CITY OF ALBUQUERQUE

**Re: De Anza,
4301 Central Ave NE, 87108
30-Day Temporary Certificate of Occupancy
Transportation Development Final Inspection
Engineer's/Architect's Stamp dated 12-25-17 (K17D106)
Certification dated 10-15-19**

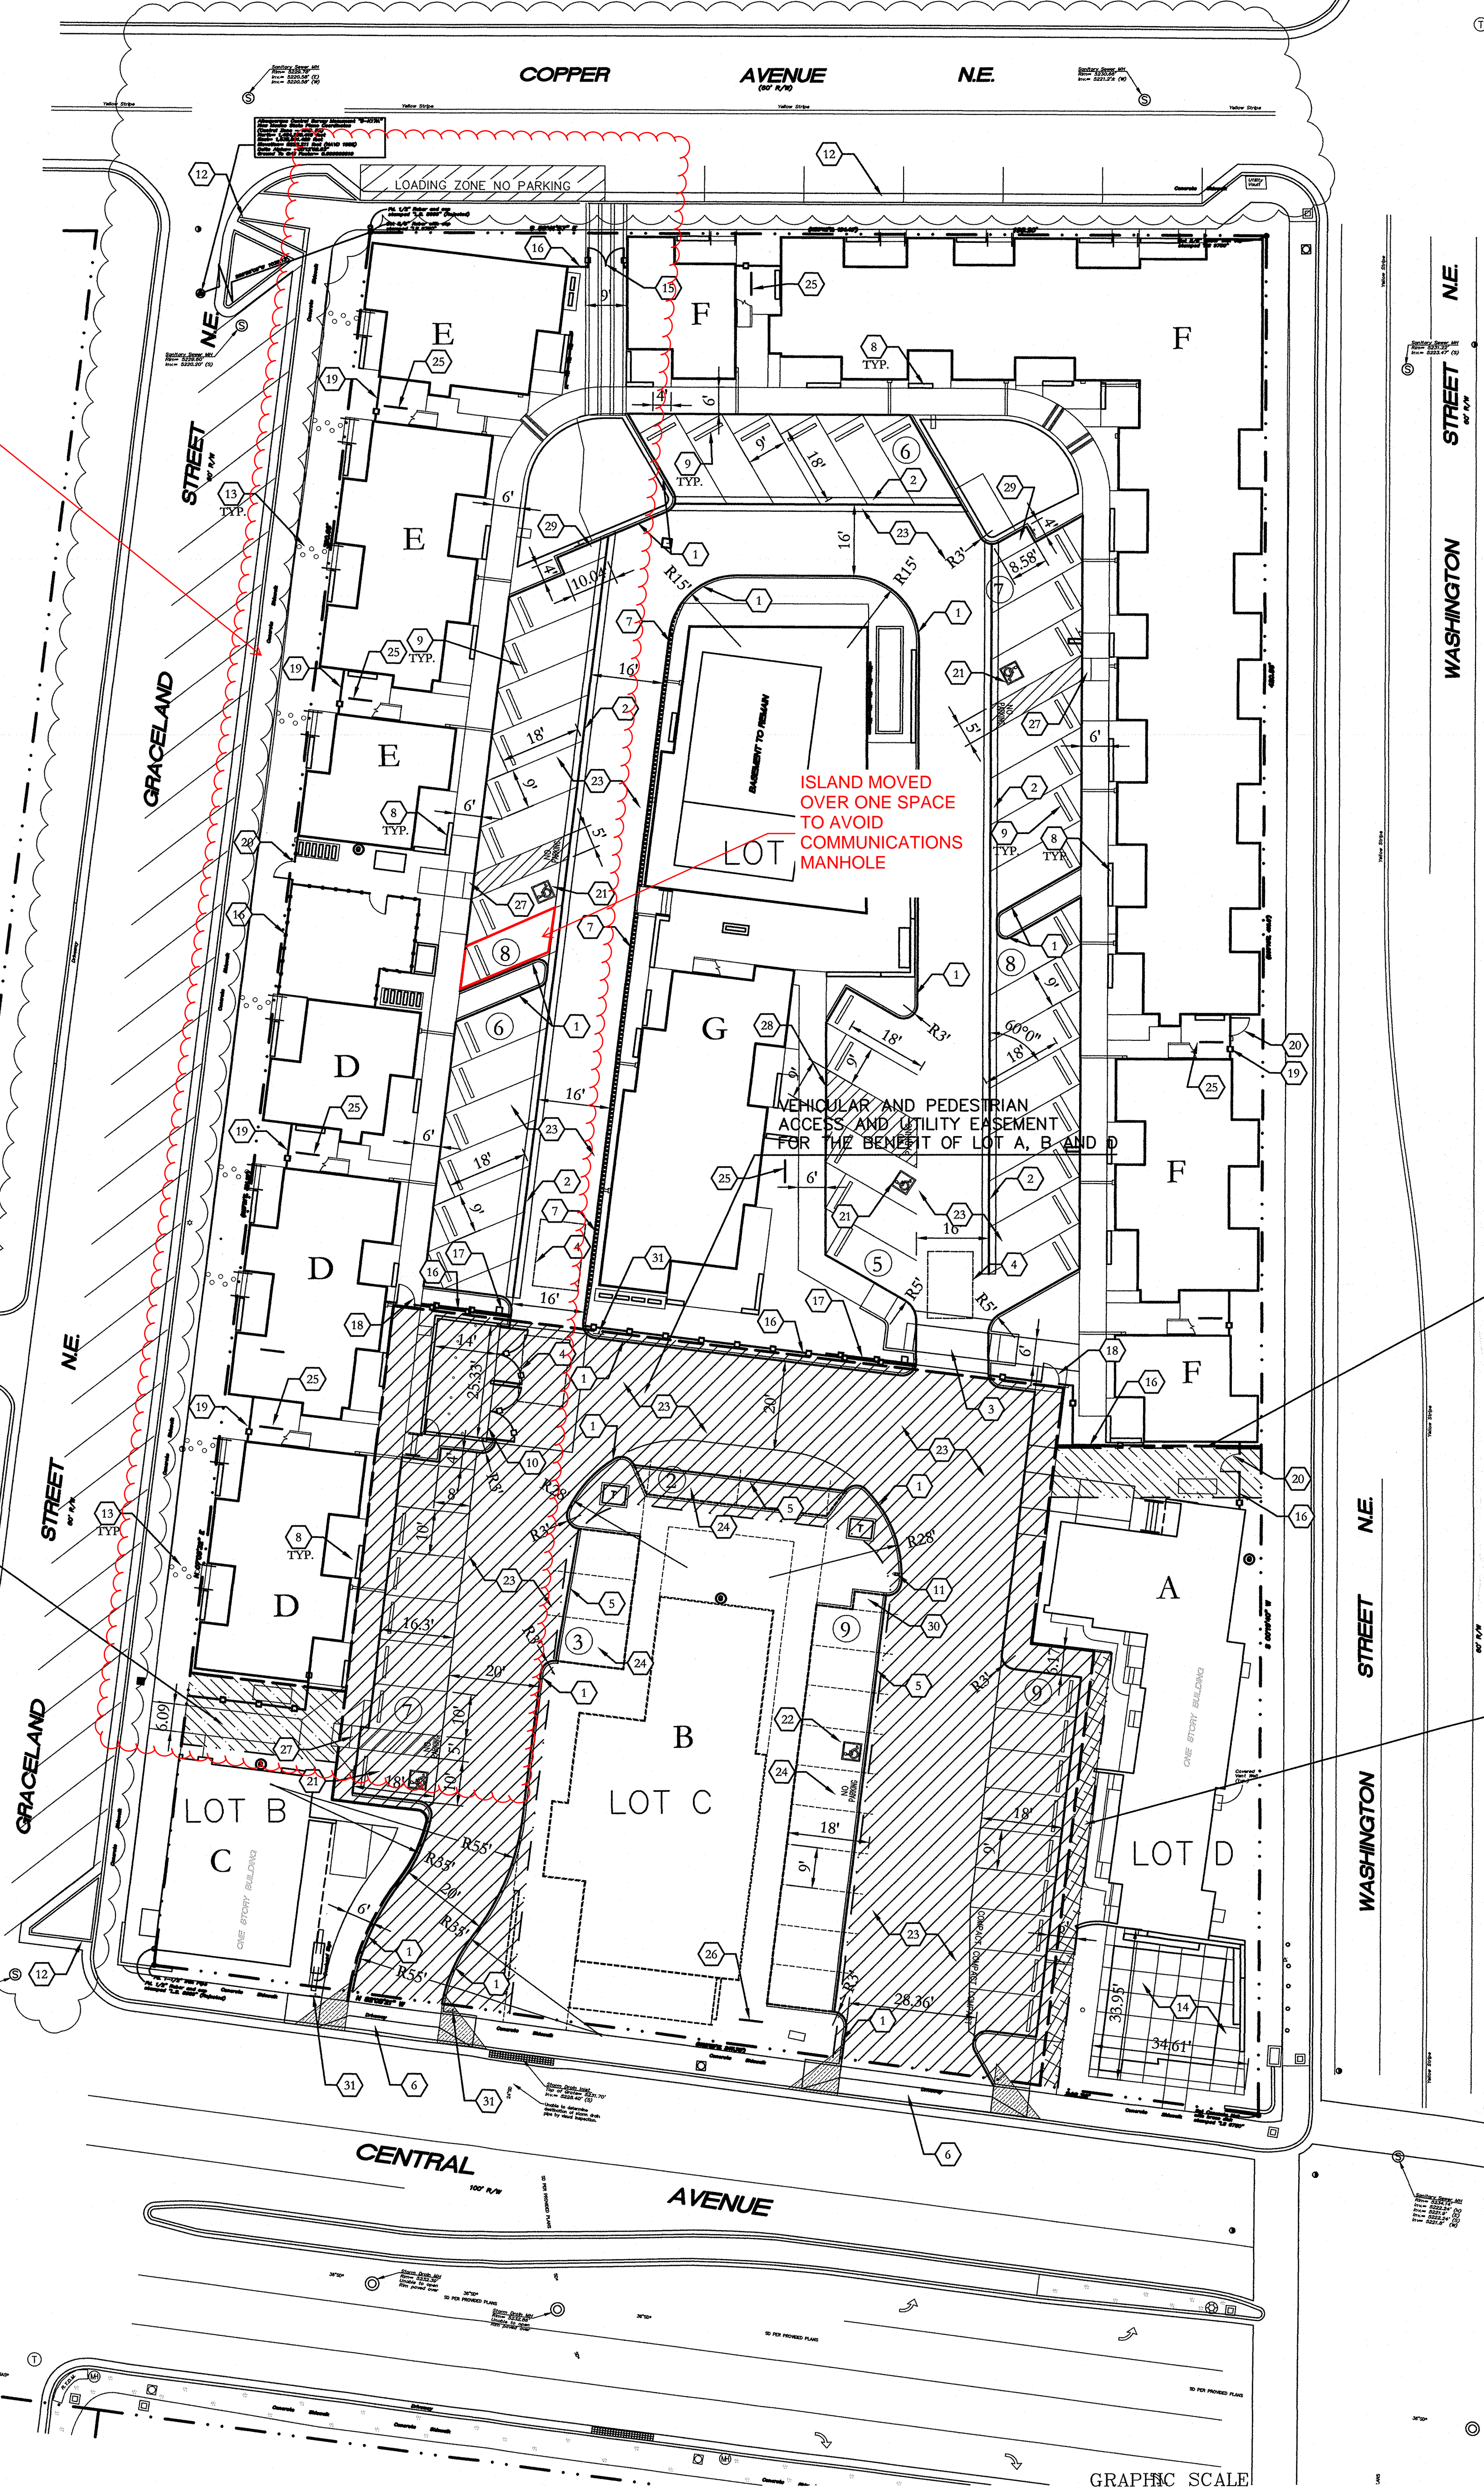
- Please place parking bumper back in ADA stall. (Removed to access manhole)
- Please remove barricade on sidewalk at the corner of Graceland & Copper
- Please remove construction materials and debris.
